CITY OF ALBUQUERQUE

**Re: Fiesta Kia Group,
7400 Lomas Blvd NE, 87110
Request for Certificate of Occupancy
Transportation Development Final Inspection
Engineer's/Architect's Stamp dated 6-13-18 (K19D152)
Certification dated 4-5-19**

Based upon the information provided in your submittal received 4-8-19, Transportation Development cannot approve the release of Certificate of Occupancy for the above referenced project.

1 SITE & TRAFFIC CIRCULATION PLAN
Scale: 1" = 20'

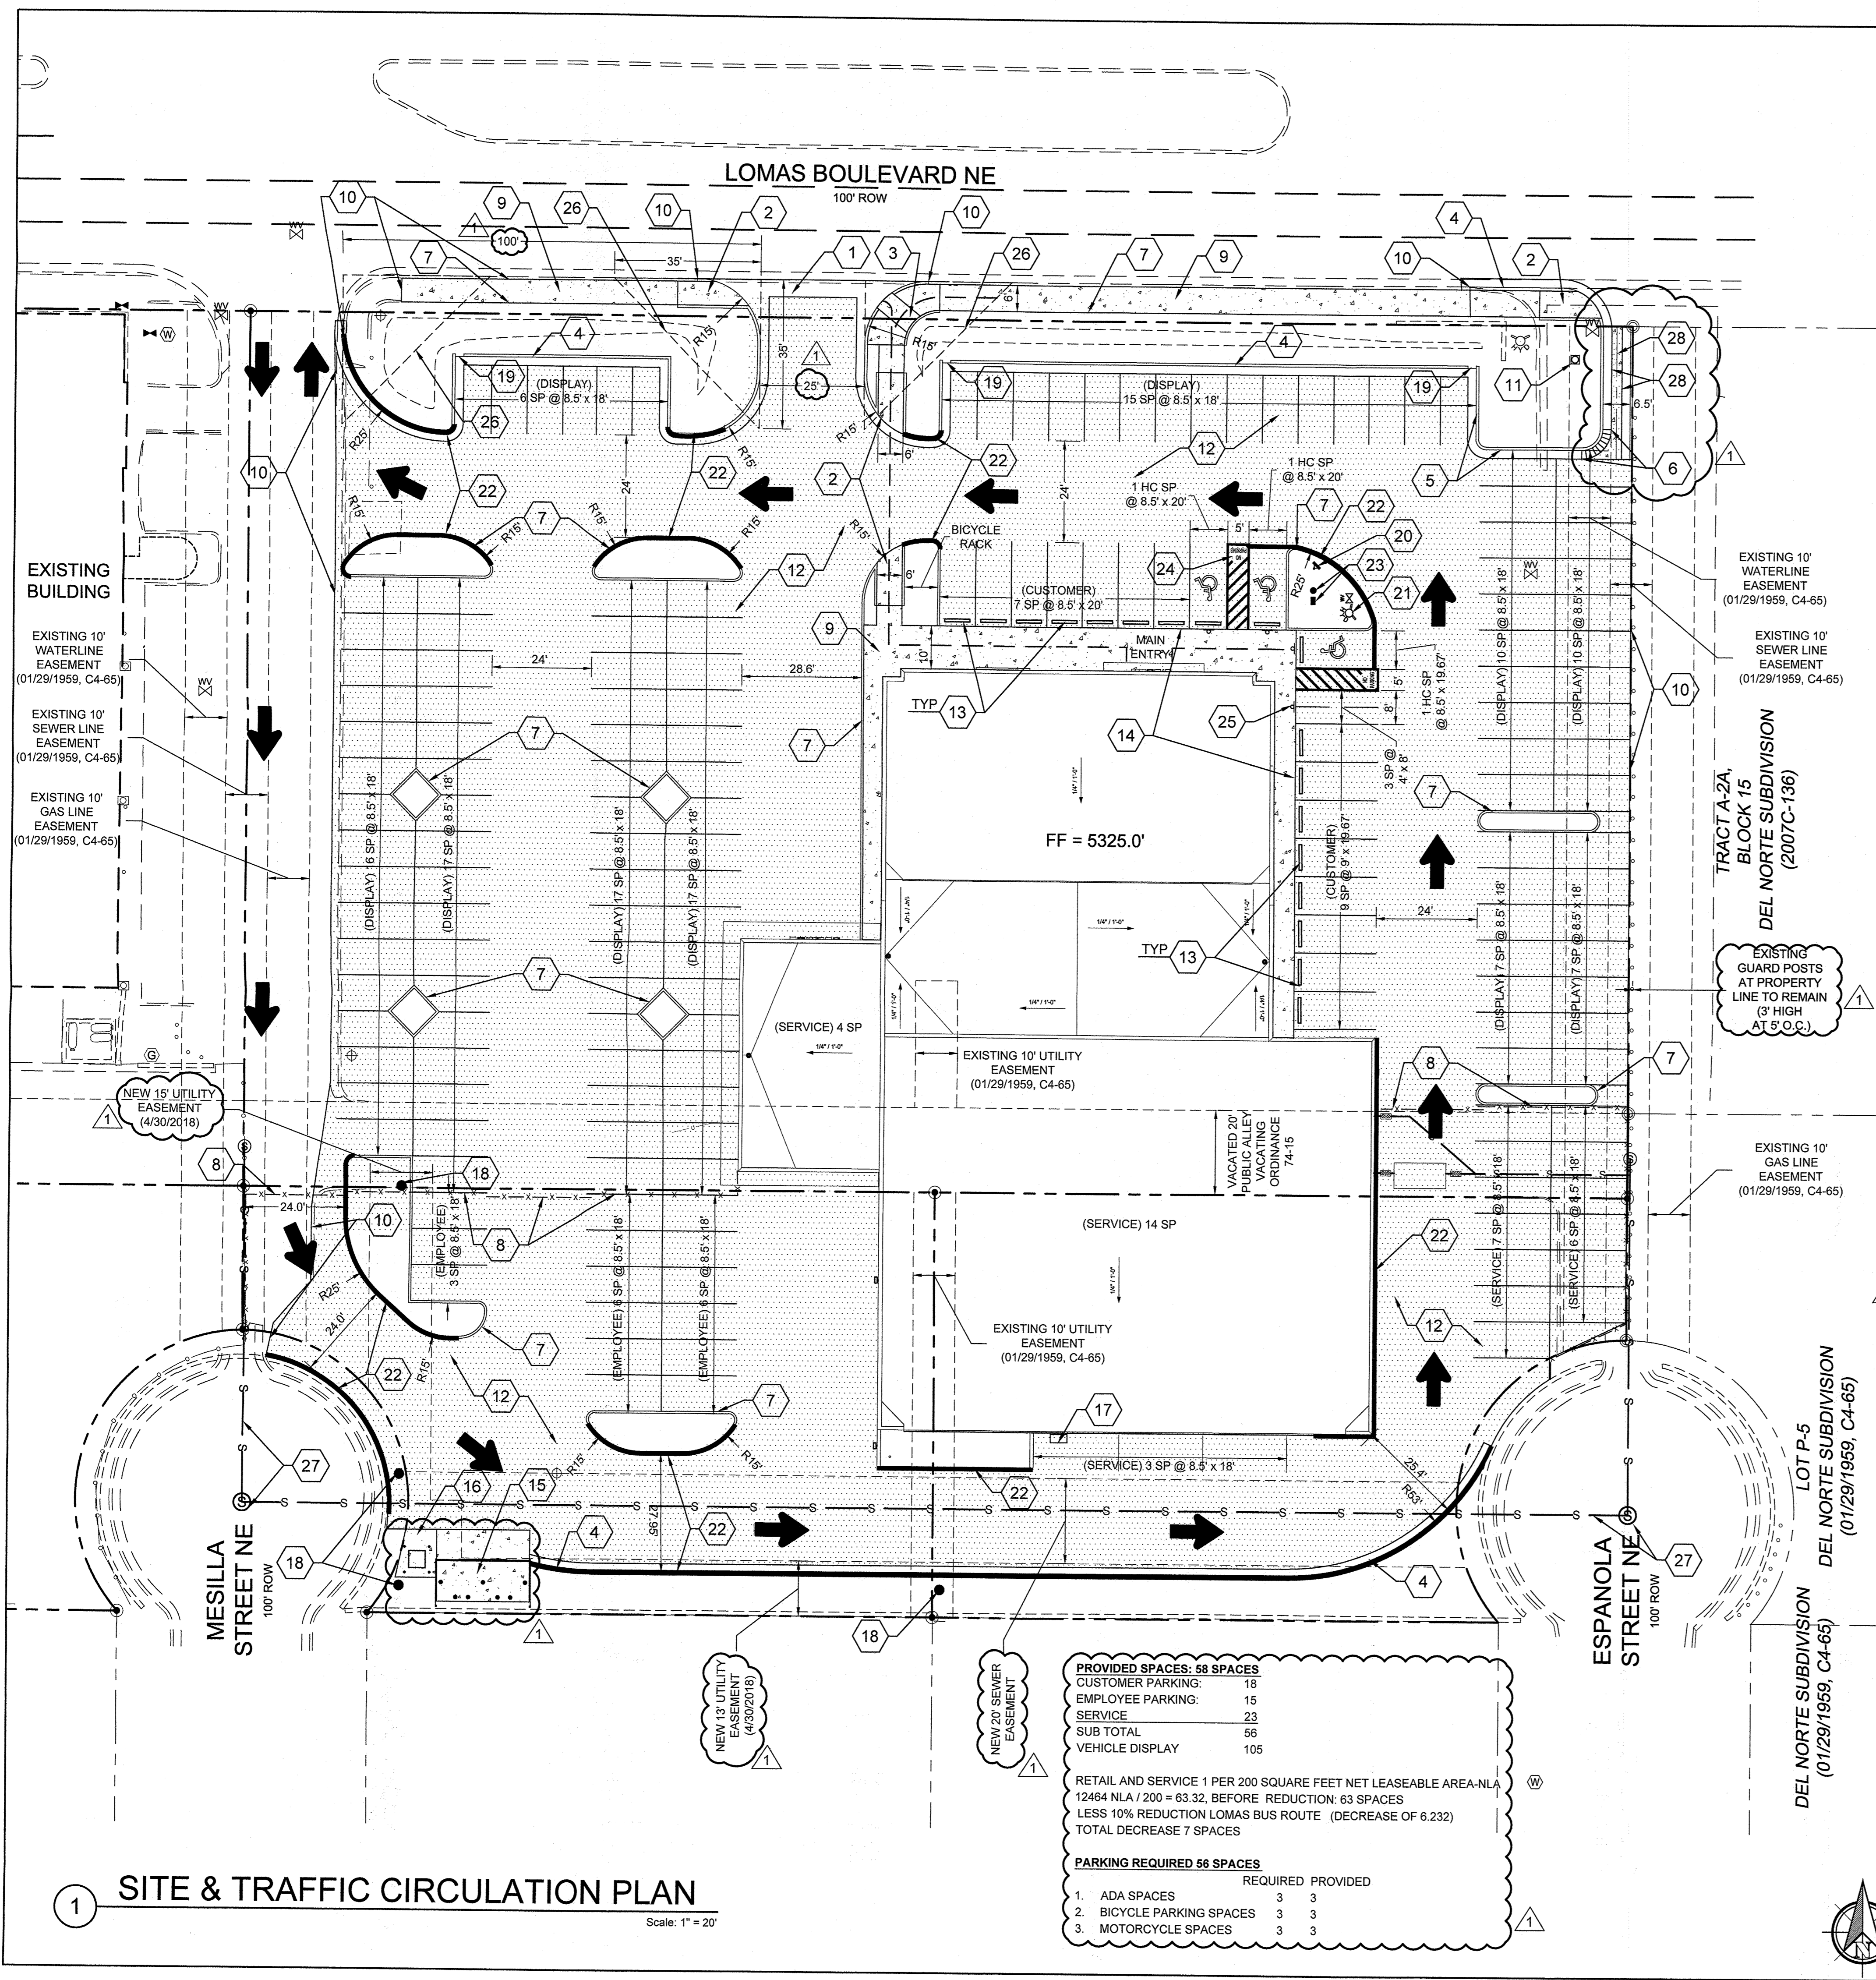
- Please correct Motorcycle Parking
(See attached Photo. Stalls must be accessible and not blocked.)
- Please remove construction materials, debris and porta-potty
(See attached photos)
